From: Simon Davis
Sent: 21 October 2020 15:55
To: 'Natalie McKellar' [REDACTED]
Cc: Kerry Simmons [REDACTED]
Subject: RE: Springfield, Hook Lane - AL/64/20/PL

Further to the email below and our ongoing discussions regarding the protection of trees at Springfield I attach an updated Arboricultural Impact Assessment & Method Statement to accompany the application. This has been updated as per Mark's comments in terms of the drainage channel to the north-eastern corner of the site.

From: Natalie McKellar [REDACTED]
Sent: 02 October 2020 13:37
To: Simon Davis <Simon.Davis@arun.gov.uk>
Cc: Mark Warwick <Mark.Warwick@arun.gov.uk>; Kerry Simmons [REDACTED]
Subject: Springfield, Hook Lane - AL/64/20/PL

Drainage Strategy				Draining The
Engineering Details				
Drawn	Checked	Scales	Paper Size	Date
JN		1:250	A1	08.19
Job No.				Revision
KNC/1932	602-01			C

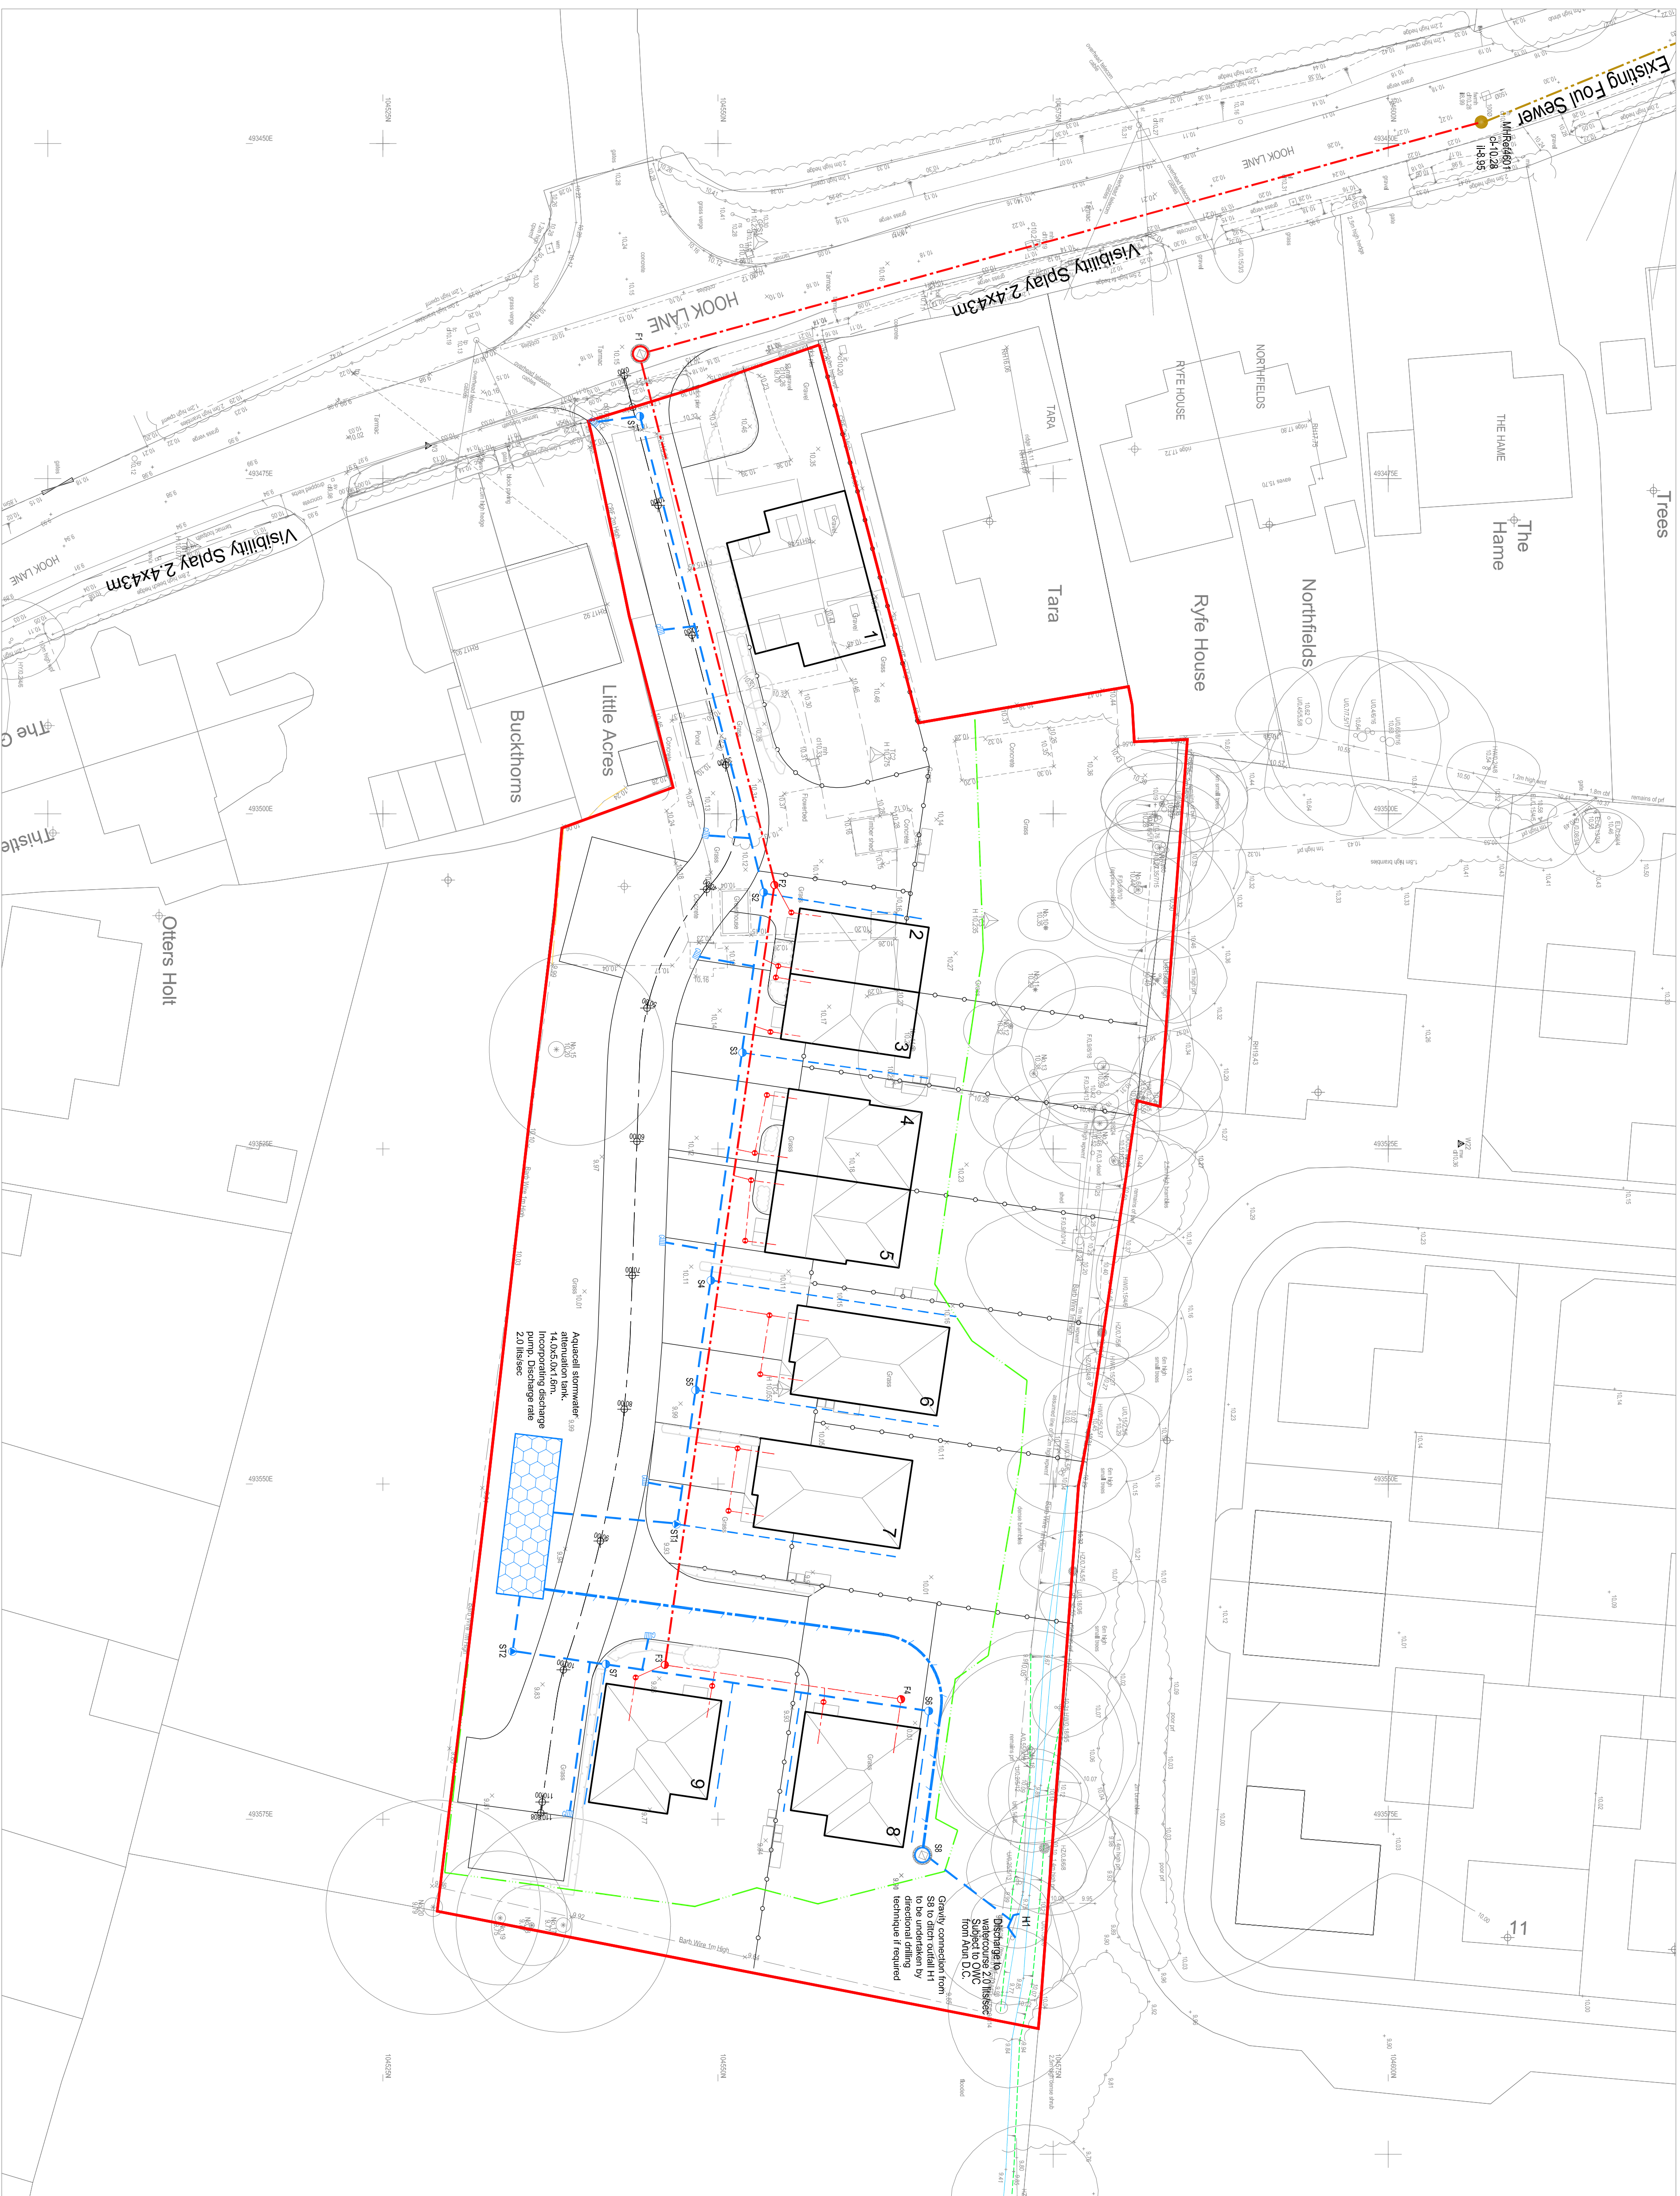
- (1) You amend the Method Statement to make it implicit that exploratory excavation will be carried out and if roots are present along the drainage channel line then directional drilling to take place; or
- (2) You take a new drainage run in a northerly direction (not quite straight north) and aim to bisect the RPAs of onsite T18 and offsite T21.

The Engineering Details Drainage Strategy for the site as illustrated (dwg. no. 602-01, Rev C) is broadly respectful of retained trees and their growth potential, with the obvious exception being chosen route of surface water discharge to the north boundary watercourse and construction of headwall – both within the RPA of retained (off-site?) mature Cypress T21. Directional drilling technique is proposed 'if required'. I say it is necessary unless exploratory excavation findings permit standard trenching. All that to be set out in the required Arboricultural (Impact Assessment &) Method Statement. ***Might it not be easier to take a more northerly route from manhole S8 and avoid significant tree's (T18 & T21) RPA altogether,*** subject to suitable ground levels (gravity connection)?

I have highlighted the relevant part regarding the suggested re-routing of the drainage run as whilst we appreciate the drainage is currently shown heading north-east from manhole S8 and would be within the edge of the RPZ of T21 (circled in orange) if we move the drainage run to a more northerly position from S8 (orange arrow) as suggested this would encroach more within the RPZ of T18, which I believe is a Category B tree (T21 being a C category tree). We are keen to work with you to make revisions and at present the drainage scheme is only indicative however we want to make sure any changes address Mark's concerns in order to present the application with the best chance of success before Committee. As such we would be grateful for any comments you may have in this regard.

In terms of the comments regarding drainage, as demonstrated by drawing no. 602/01 Rev C prepared by Kazy's Narbutas Consulting, the surface water storage tank has been specifically sited outside of any tree protection areas to the southern site boundary and as such adequately safeguards the retained trees.
